LANDSCAPE ARCHITECTURE DESIGN REPORT - ADDENDUM 01

New Primary School in Mulgoa Rise

APPLICATION NO. SSD-11070211

L-SSDA- 006 05 © 2019 ABN 16 002 247 565 0 110 20 30 40 50 60 70 80 90 100

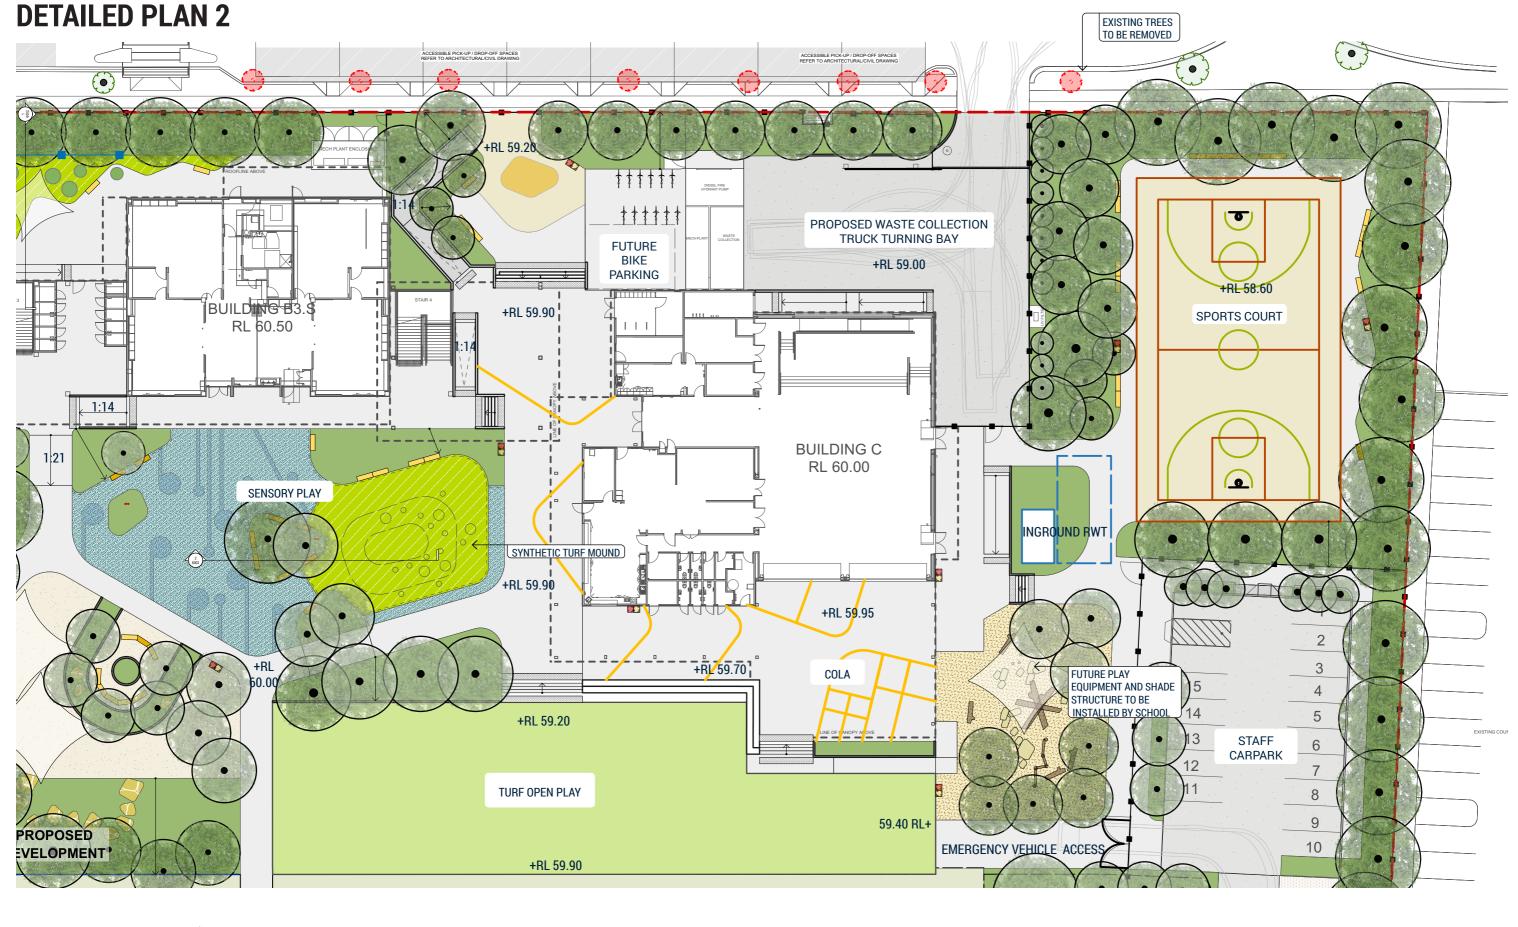
Synthetic turf and rubber soft fall are proposed and located such that they are very exposed, particularly to hot summer afternoon sun. Additional canopy should be provided for these areas, particularly along western edges. Alternatively, shade canopy/ structures should be provided over these surfaces to protect students from the extreme heat these materials can emit. Ideally the playground with playground mulch should also be provided with additional canopy.	- Shade structures have been indicatively shown and the school is to install these at a later date. - Synthetic turf and rubber Softfall play areas are proposed to allow for shade structures to be installed by school in the future. - Two shade structures have been proposed to the Mulched playground, please refer to Drawing L-SSDA-007; One shade structure proposed to the outdoor learning area to the Block 3.S Support Unit, please refer to Drawing L-SSDA-006.
